Application for a Non-Material Amendment Following a Grant of Planning Permission

Erection of First Floor Extension Over Existing Garage

2026/62/90186/E

Non-Material Amendment(s) Sought

client Dr. K & Mrs. B. HELLAWELL			
project PROPOSED FIRST FLOOR EXTENSION OVER GARAGE			
address THORNCLIFF SPRING FARM 12 THORNCLIFF GREEN KIRKBURTON HUDDERSFIELD HD8 0UQ			
drawing title ELEVATIONS AS PROPOSED (sheet 1 of 2)			
scale	prefix	drawing No	rev
1:50/100 @ A3	2025.05	(KBH) PD 06

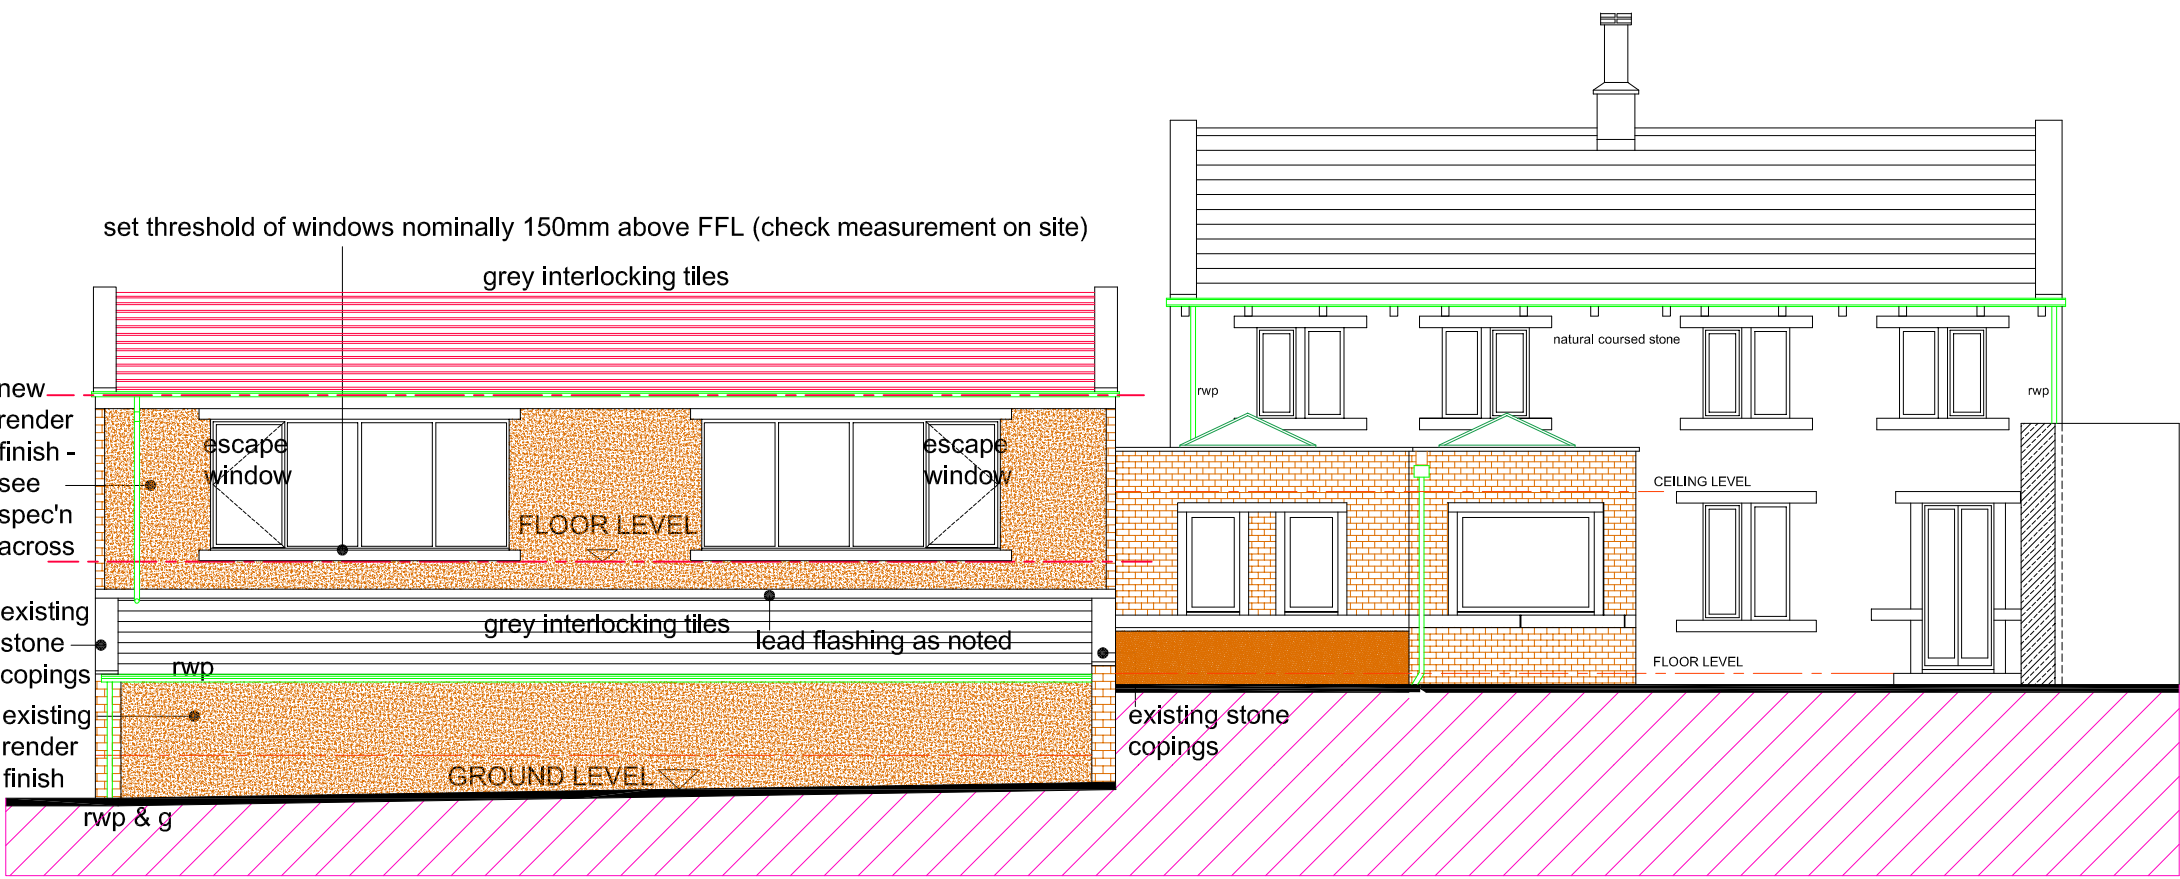
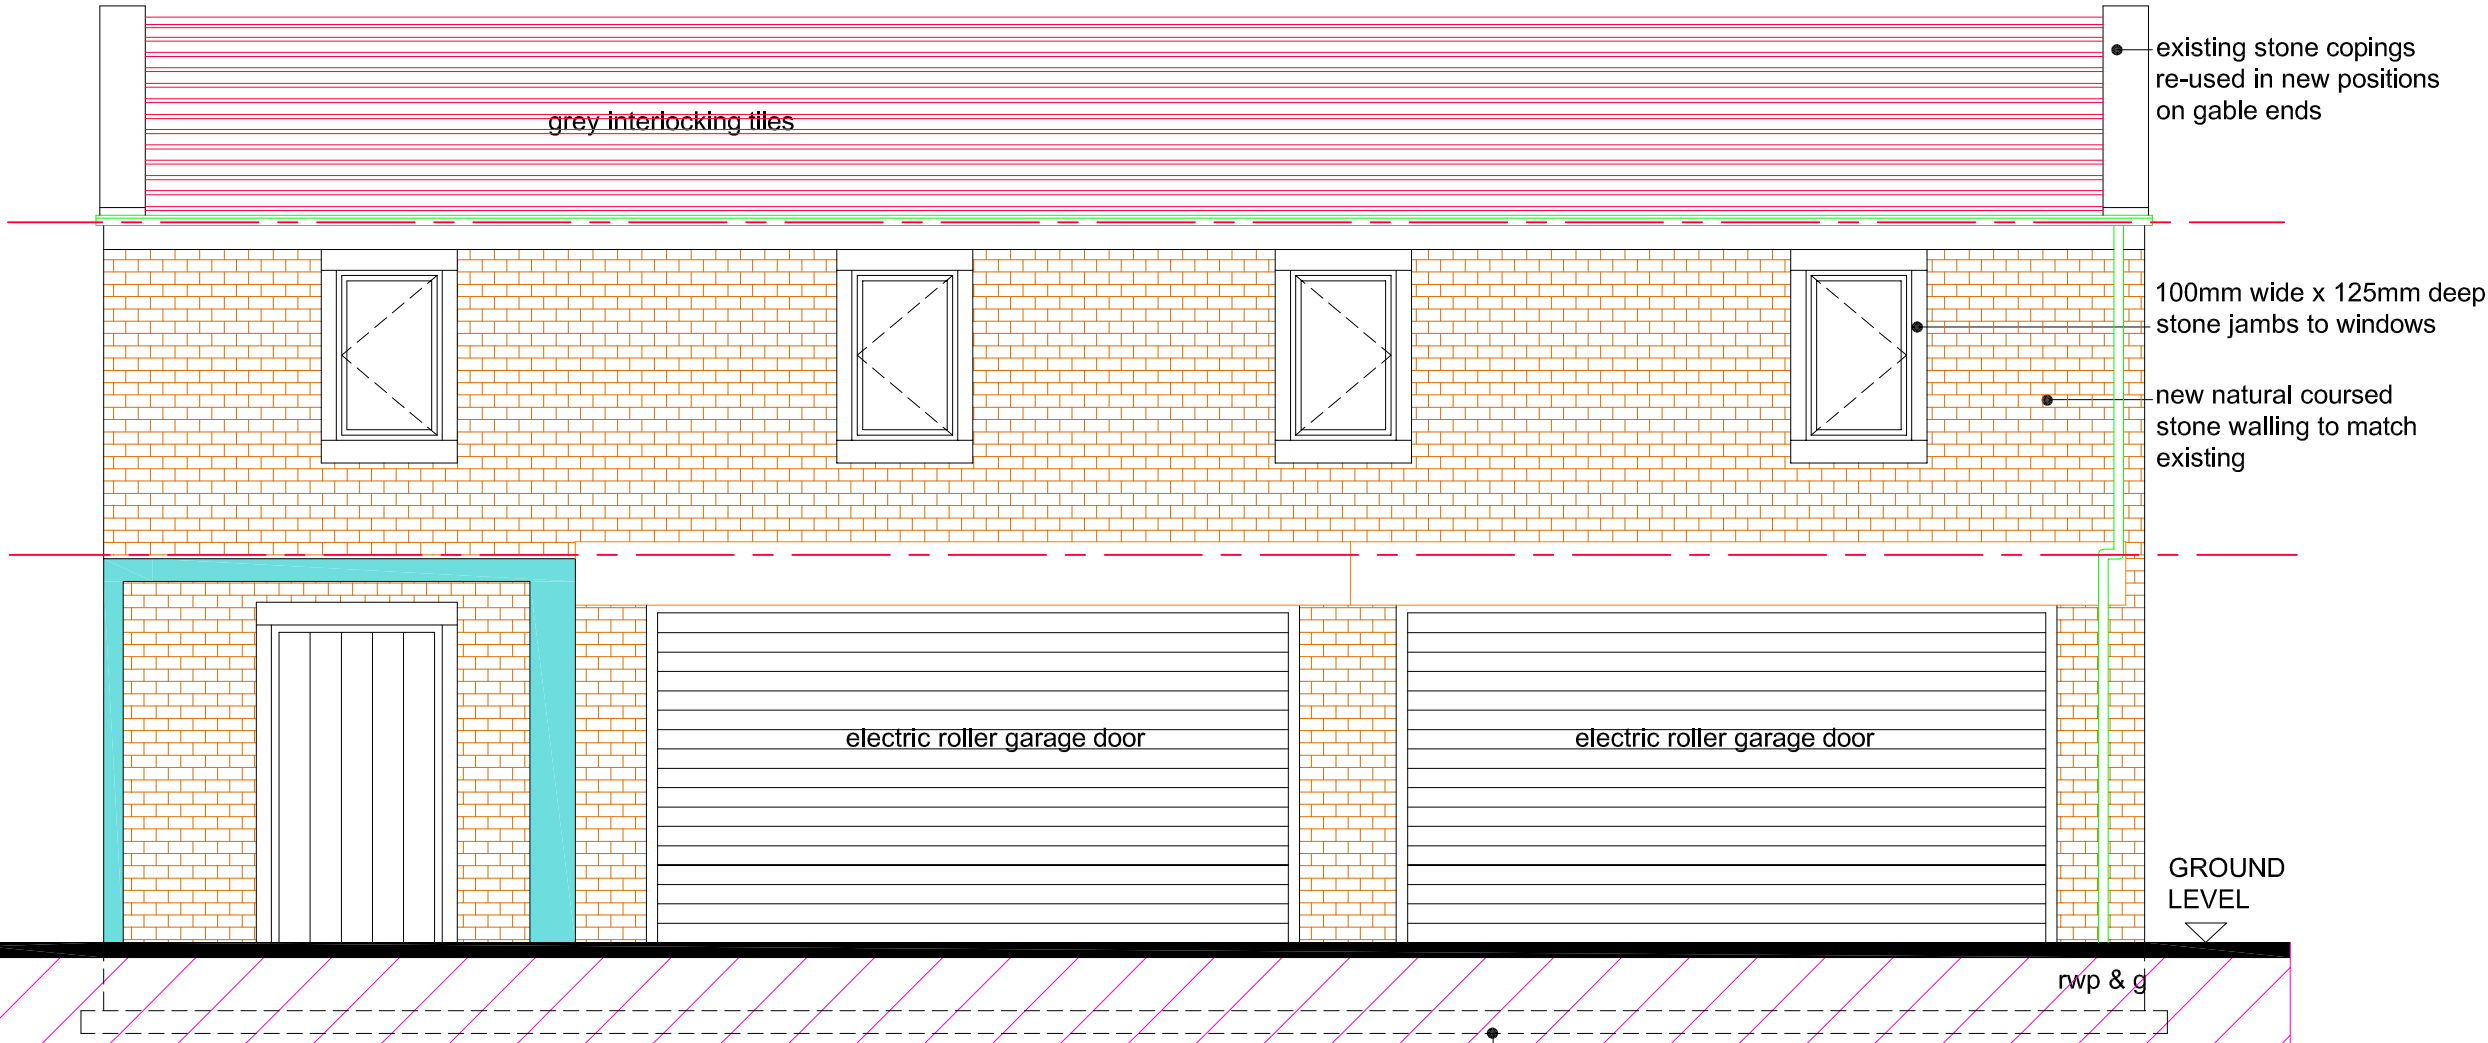
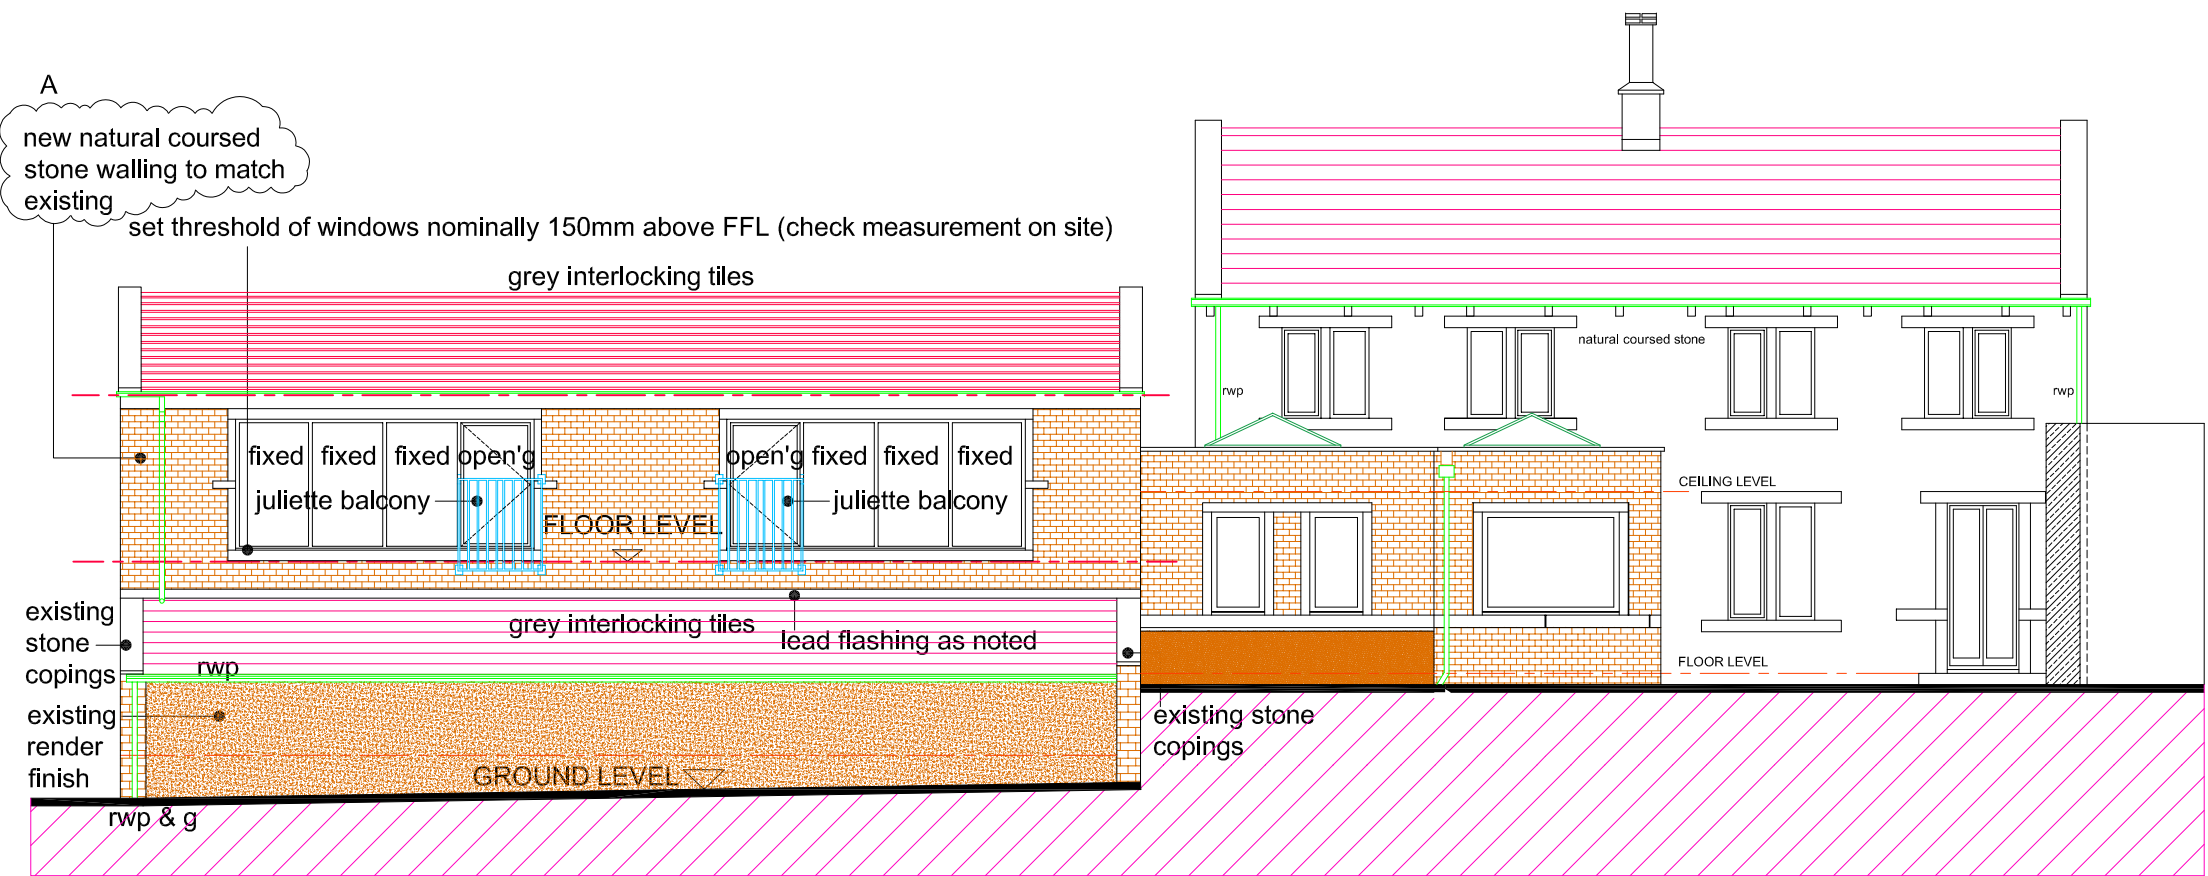
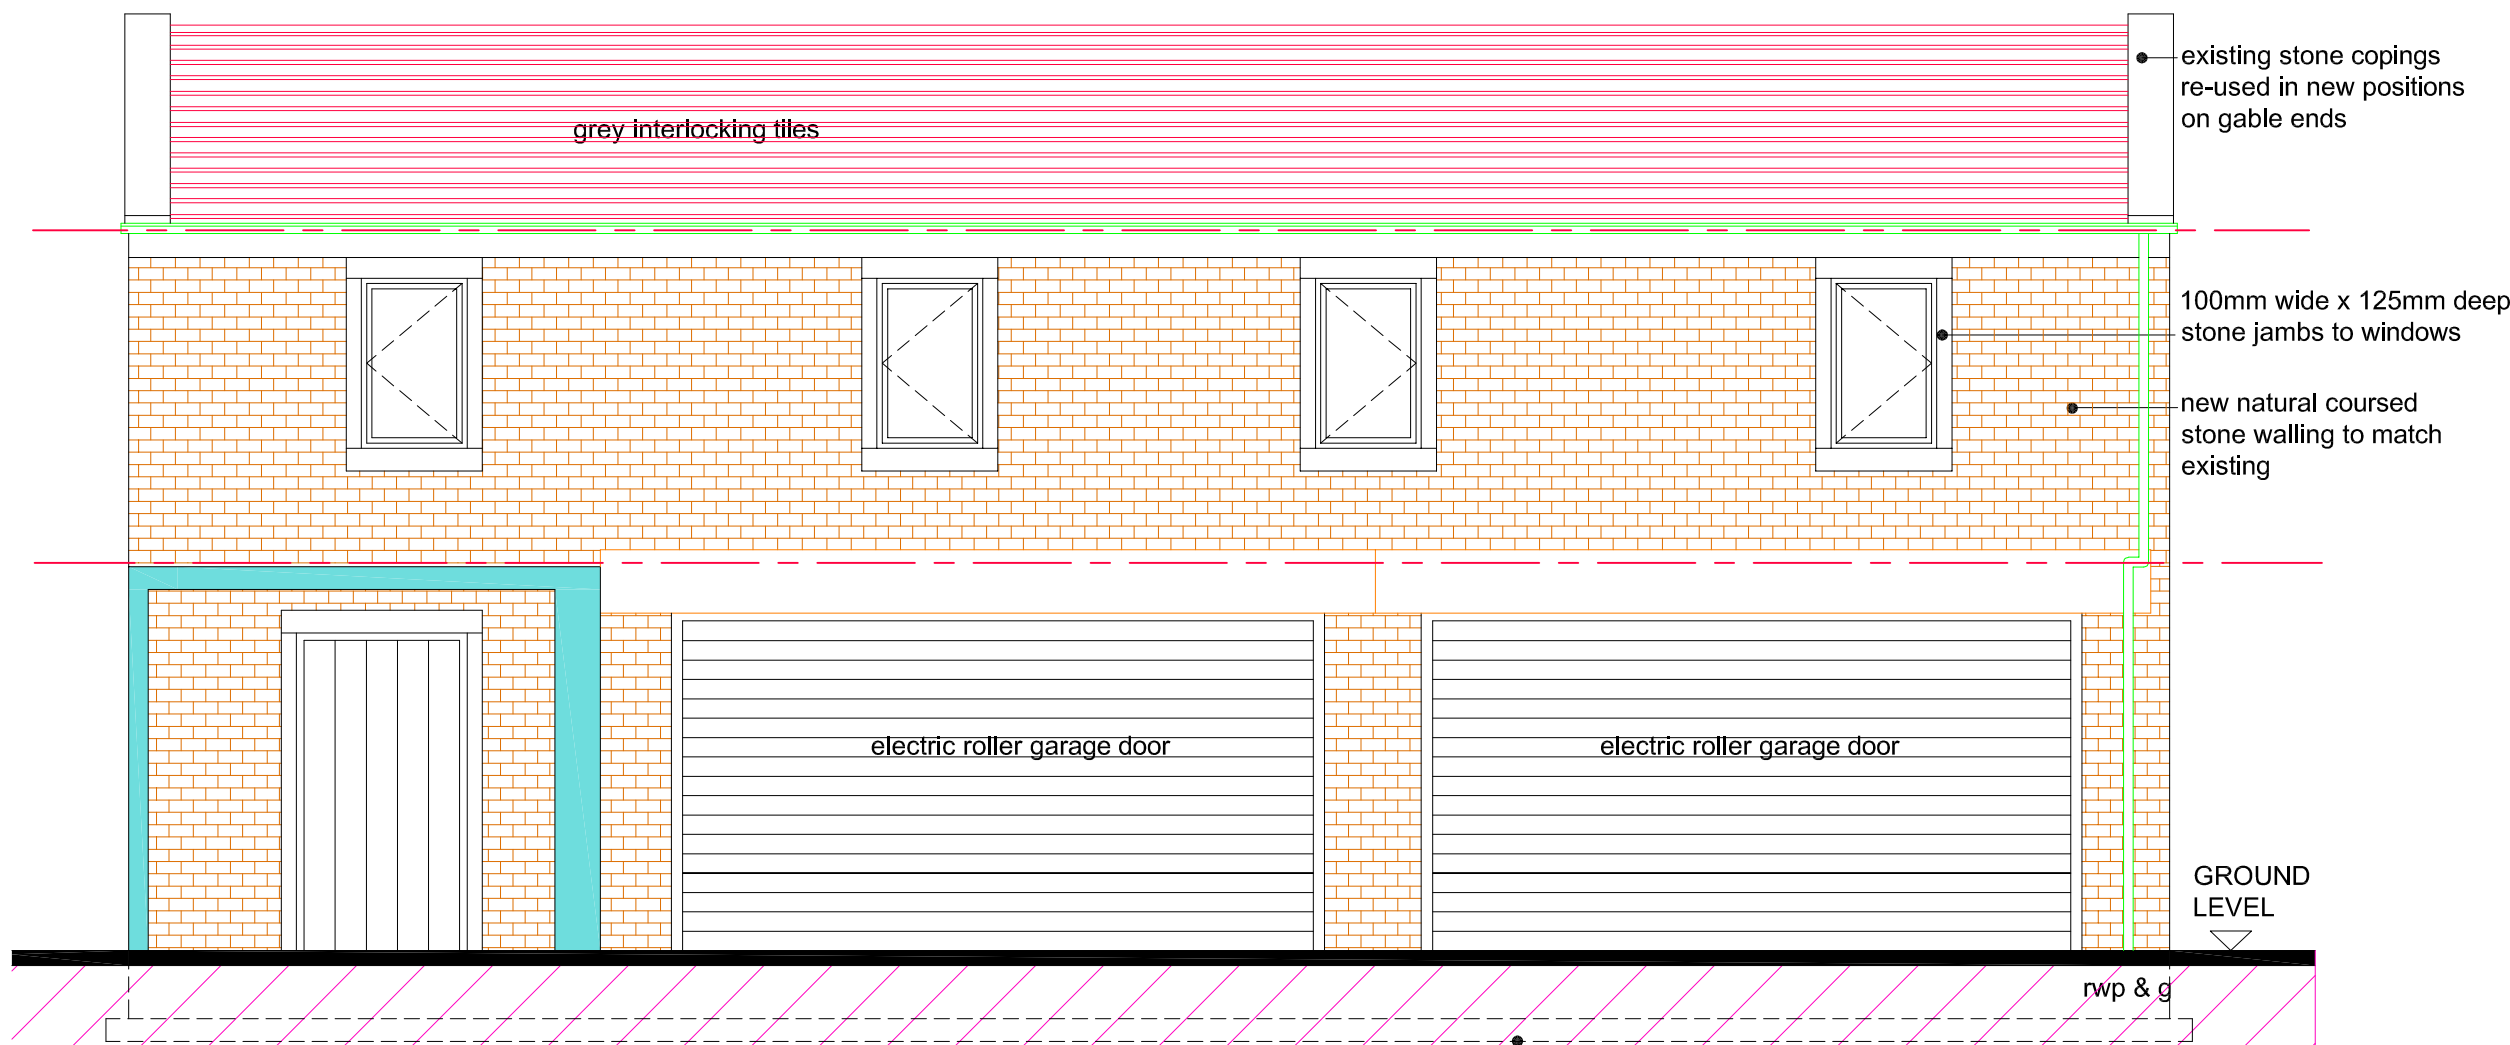
To use natural coursed stone to the external leaf of the Rear Elevation to match the remaining elevations in lieu of rendered blockwork as currently shown

Client request and simplified construction from the contractor's point of view.

(KBH) PD06A
